CITY OF PORTLAND, MAINE

PLANNING BOARD

July 20th, 2015

Project Name: Jewish Community Center and Preschool/Daycare
Conditional Use and Level III Site Plan
Project #: #2015-058 (Conditional Use and Site Plan)
Address: 1342 Congress Street, Portland
CBL: 191-B016 & 017
Applicant: Jewish Community Alliance of Southern Maine
Planner: Jean Fraser

ROOF PLAN

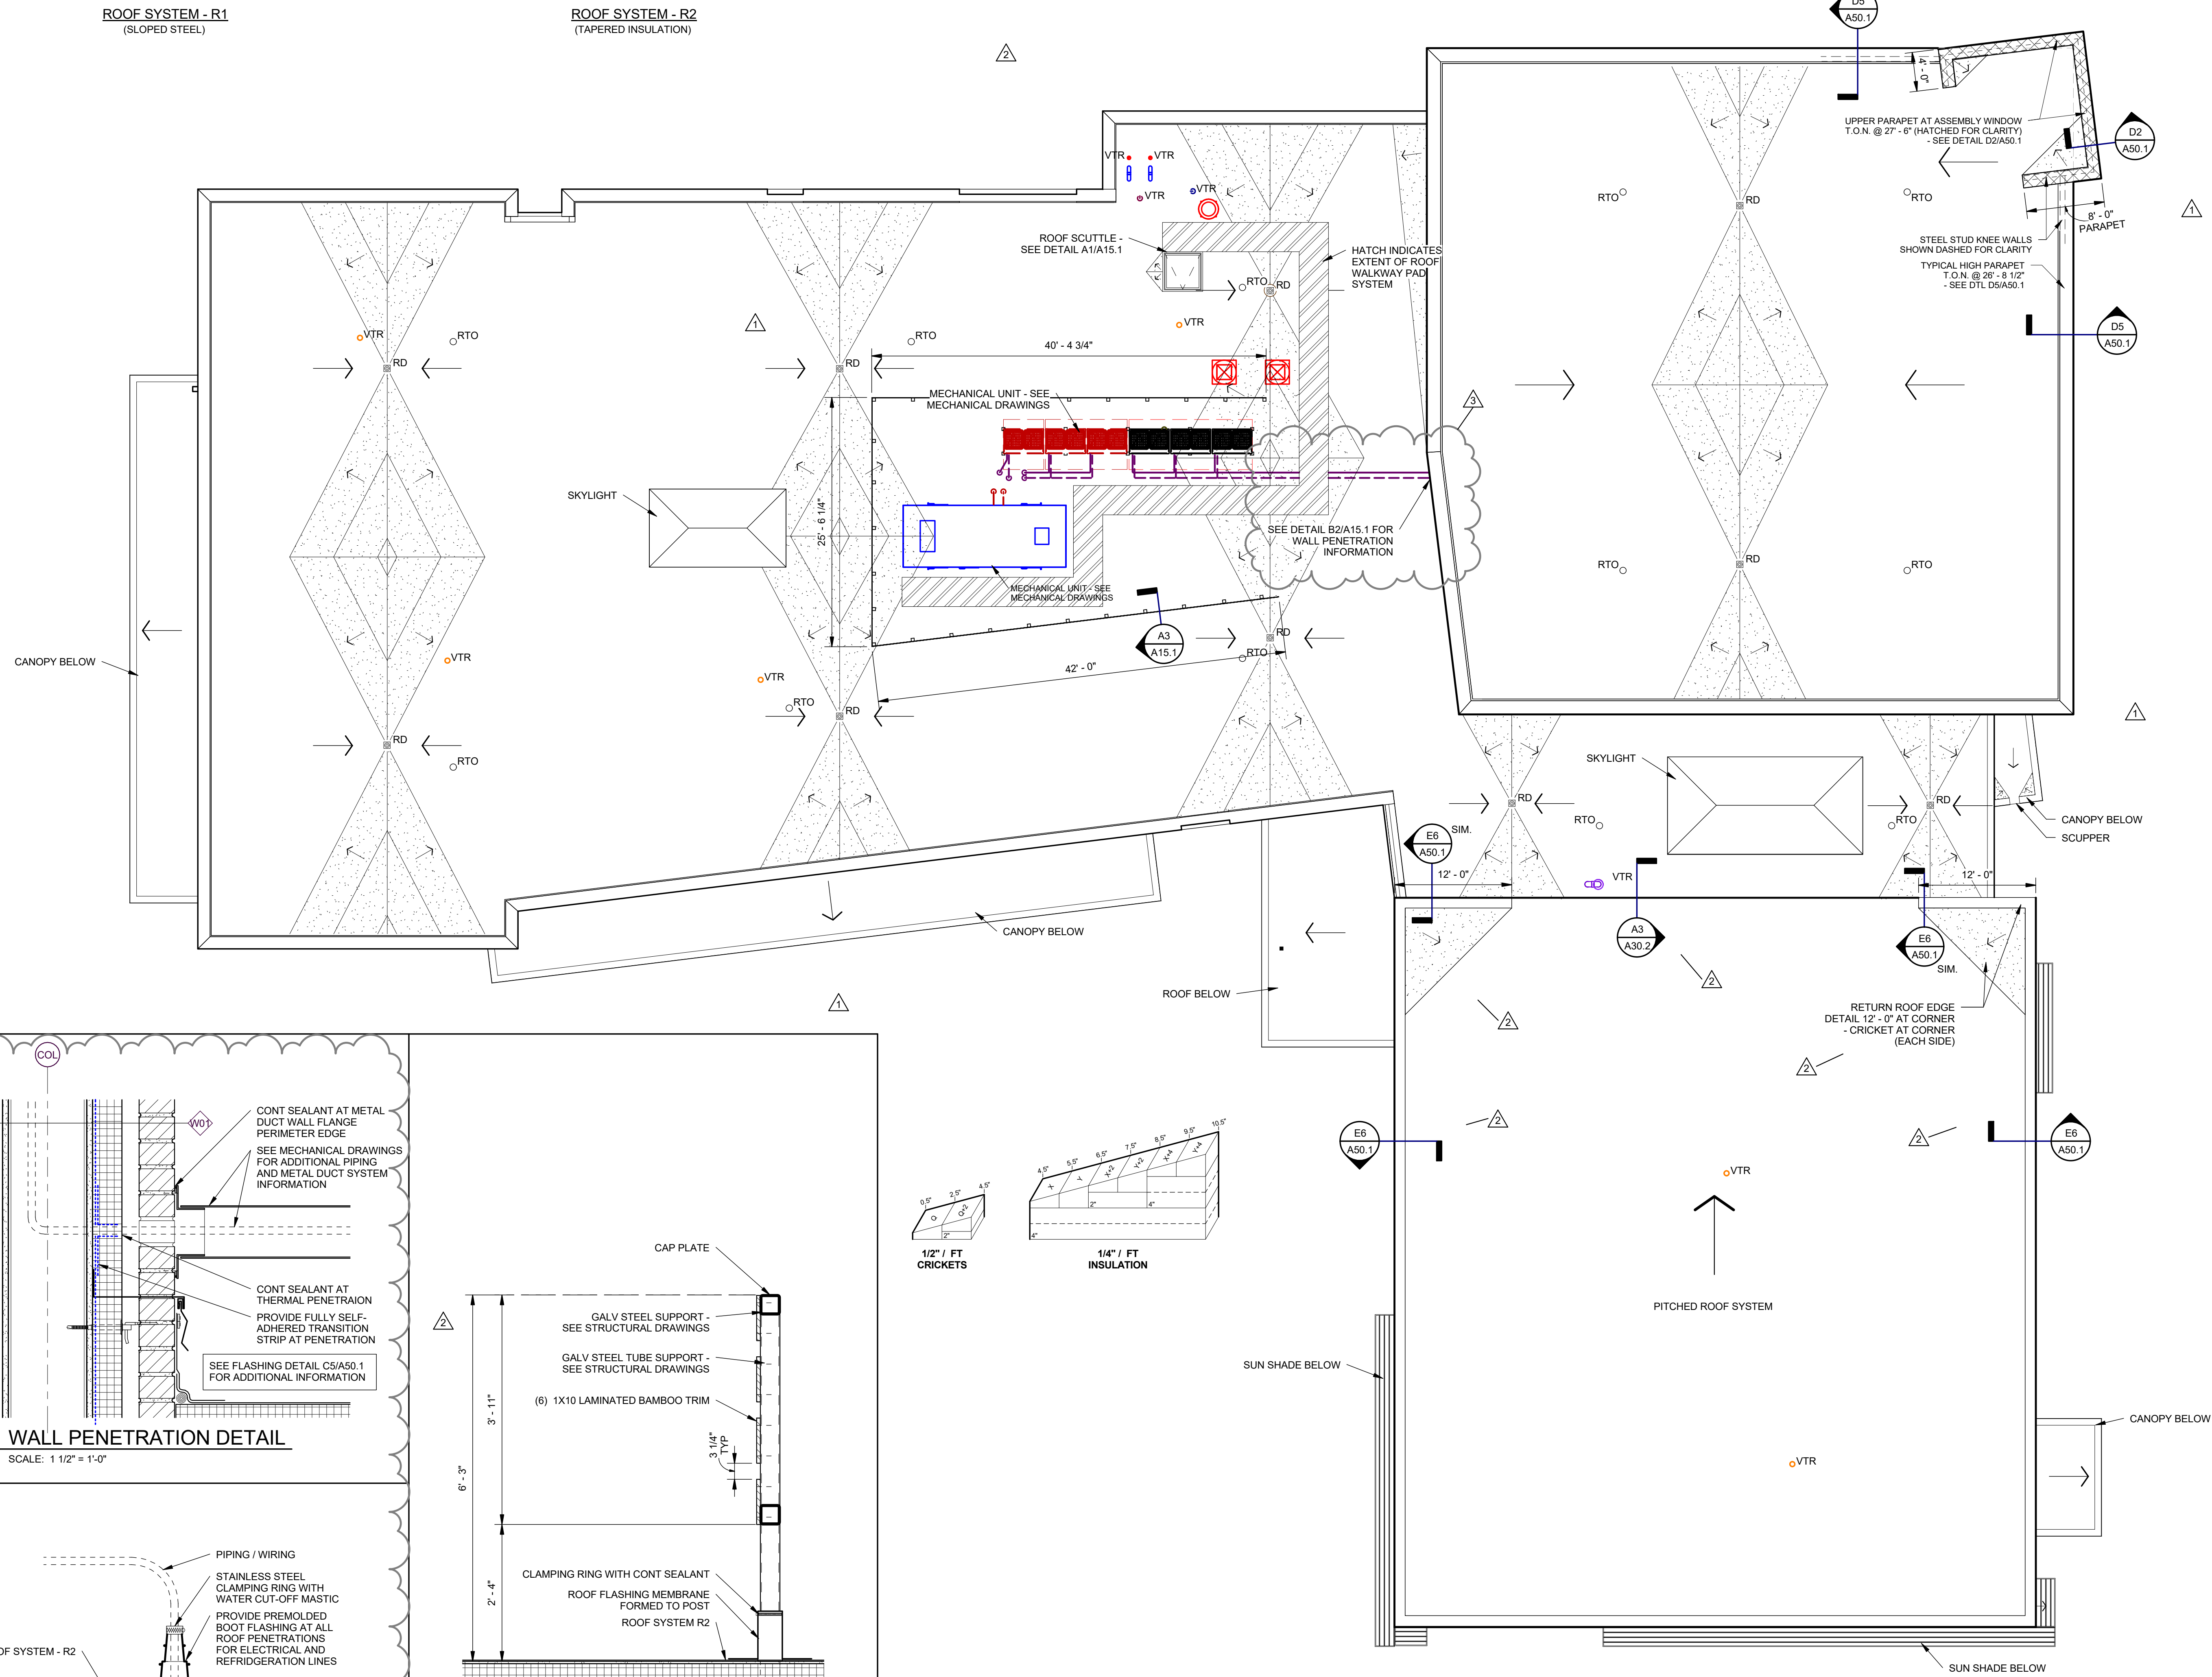
- vii. That all heating, ventilation and air conditioning shall be screened and located away from abutting residential properties.
